## **A1 in Northumberland: Morpeth to Ellingham**

**Scheme Number: TR010059**

### **7.21.1 Applicant's Responses to the ExA's Further Written Questions - Appendix A - Highways England Design Panel 27-Nov-2015 Meeting Summary - WQ GEN2.10**

**Highways England Design Panel - Meeting Summary**  
**Friday 27<sup>th</sup> November 2015 10:00 - 15:00**  
**Historic England, London**

Coquet Bridge General Arrangement outlining launch sequence.

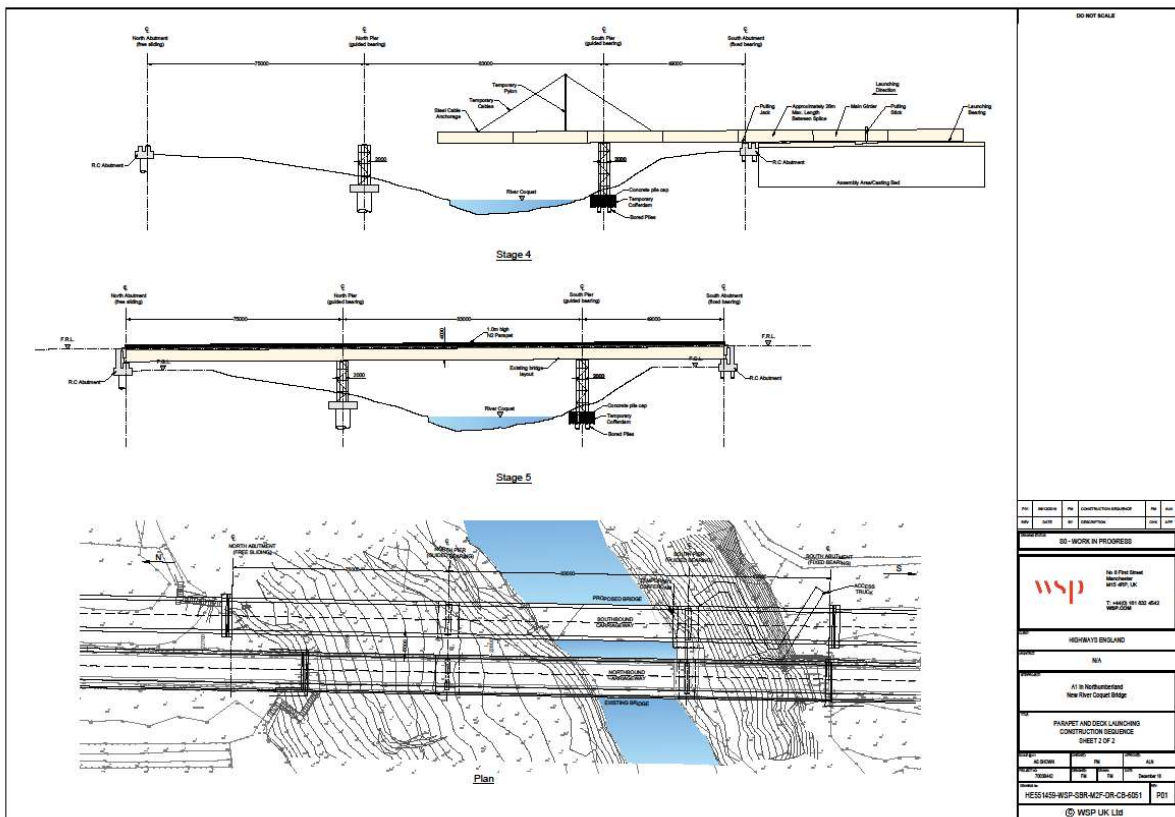
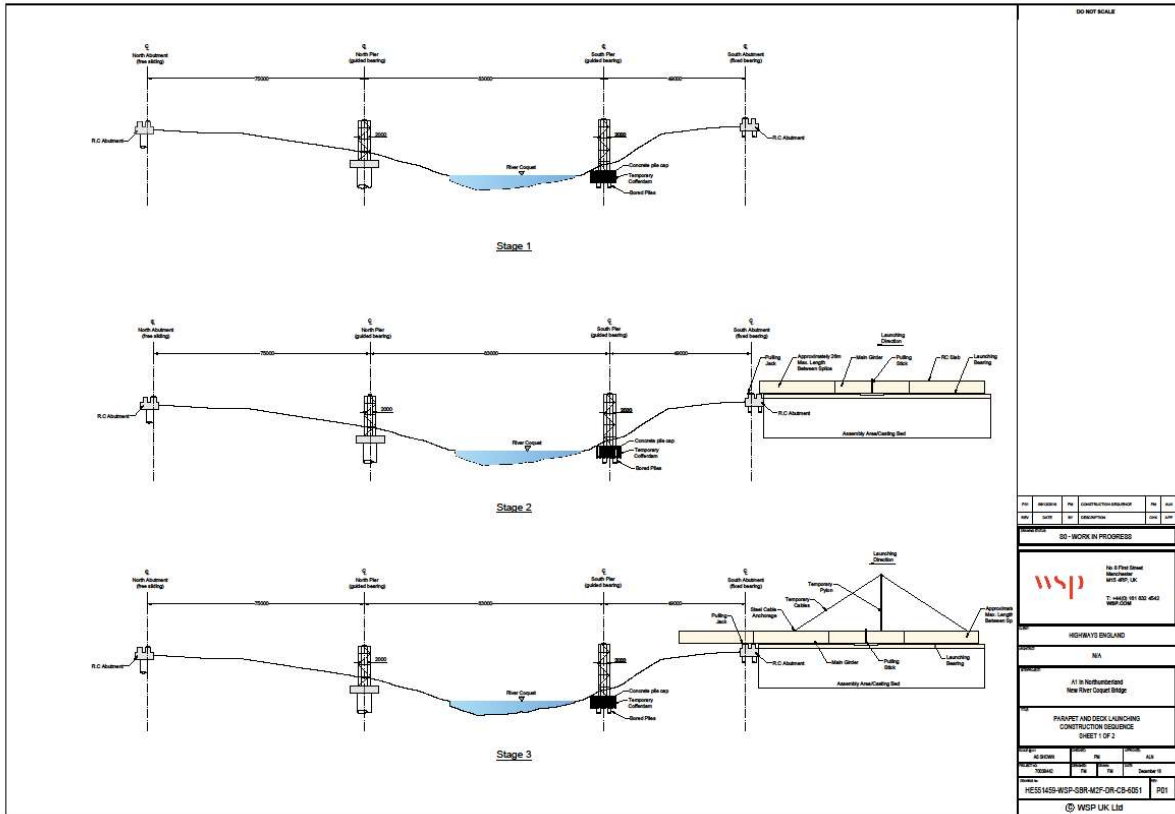
- [REDACTED] and [REDACTED] explained to the meeting the challenges they are facing on this scheme. In particular, they sought advice from the panel on the factors to consider relating to a proposed new bridge over the River Coquet site of special scientific interest (SSSI) and ancient woodland valley below.

- New bridge form and alignment vis a vis the existing structure were discussed. Avoiding the SSSI via route alignment should be considered. If an impact is unavoidable, adverse effects should be minimised and opportunities for enhancement sought. The biodiversity resource is a scheme priority.

- Early engagement with local Natural England (and Historic England) staff was recommended. All other things being equal a small impact footprint was favoured while exploring opportunities for light (and moisture) to reach the valley and allow vegetation to flourish. Woodland soil preservation and possible translocation should be considered.
